Our reference: 7746851  
Contact: Gavin Cherry  
Telephone: (02) 4732 8125

24 July 2017

**Response to modification application for the Oakdale South Employment Lands at Kemps Creek (SSD 6917 MOD 4)**

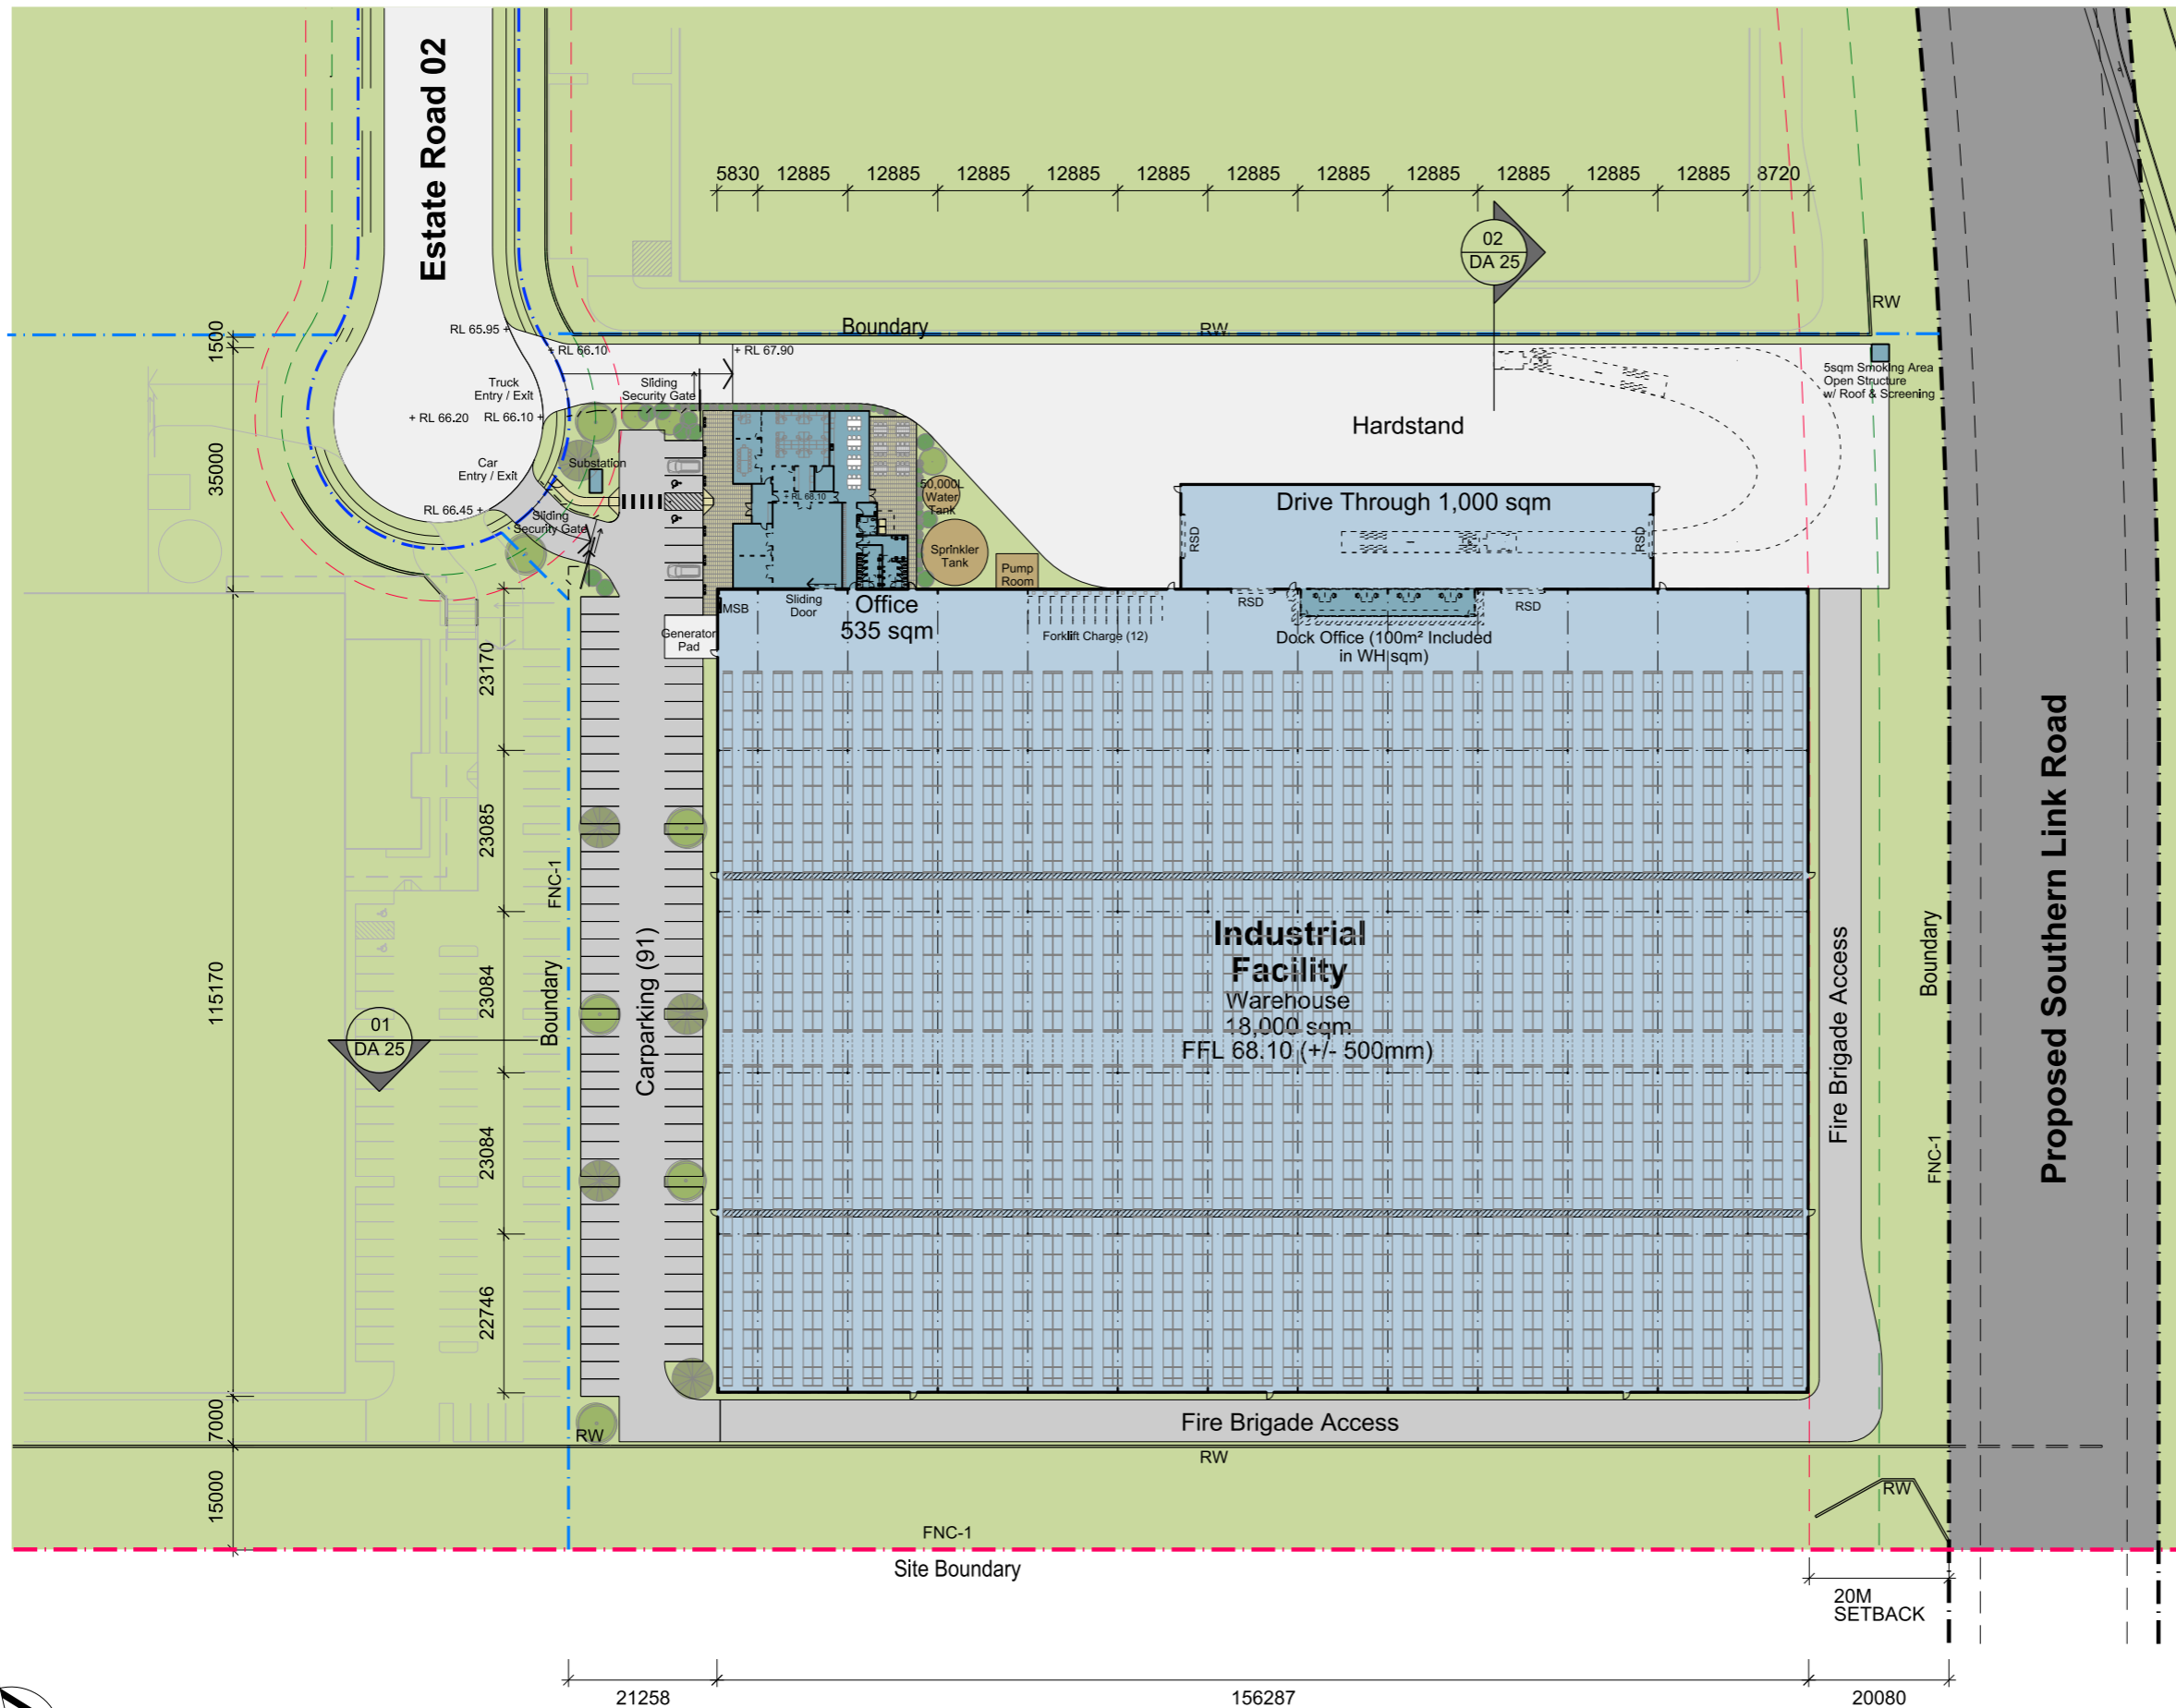
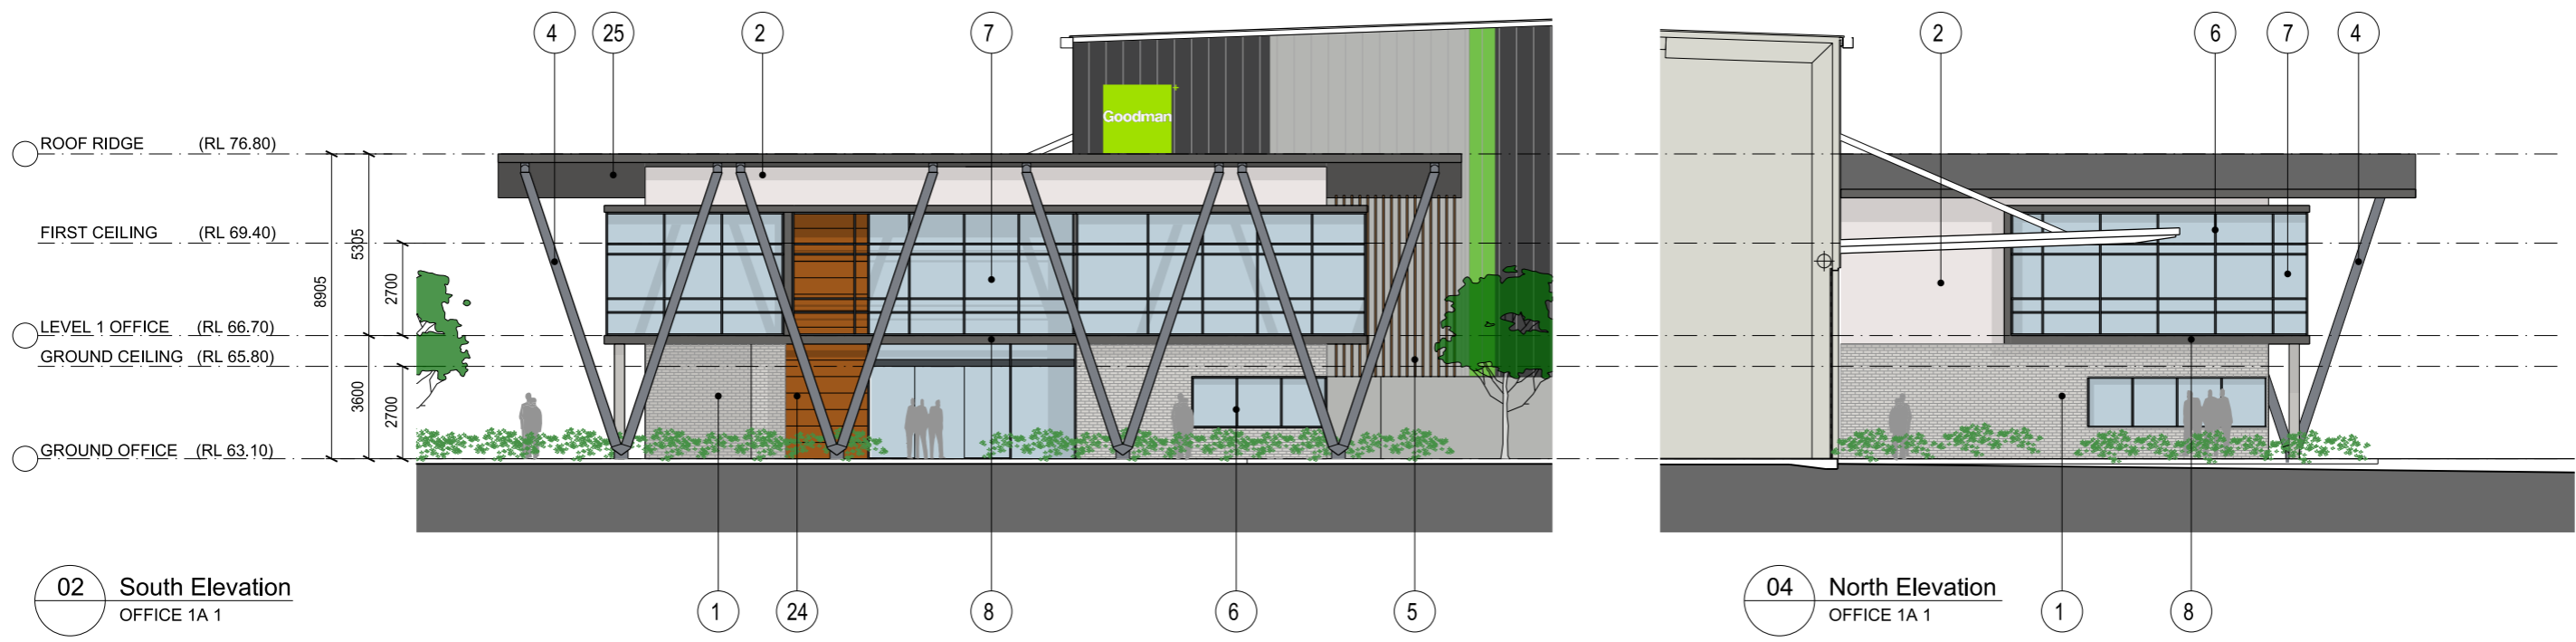
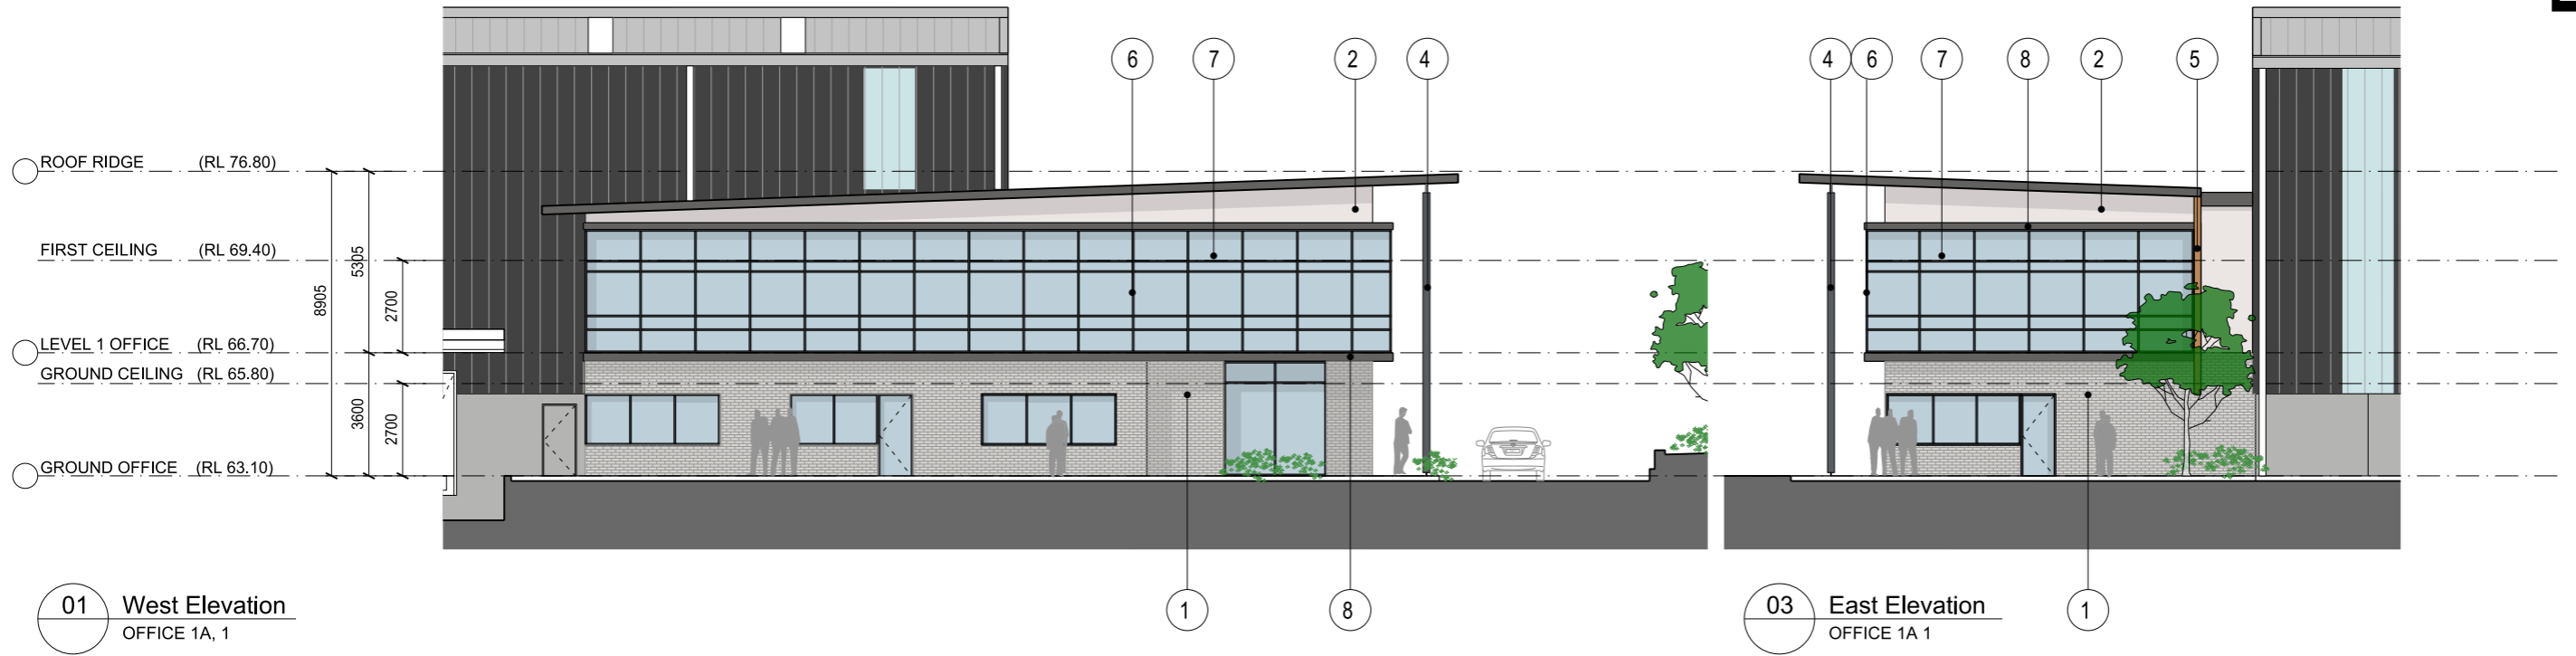
- a) The key issues highlighted by Council in previous submissions for the Oakdale South Industrial Estate still remain relevant in the assessment of this modification. In particular, your attention is drawn to the following key matters:
  - a. The configuration and layout of warehouse 1A results in a further undesirable presentation to the main entrance of the estate and opportunities to improve this presentation should be explored.
  - b. Council's previous comments on general engineering matters in relation to the technical design and layout of the local road network; and
  - c. Council's previous comments on flooding and Water Sensitive Urban Design in relation to the design and management of the proposed bio-retention basins.
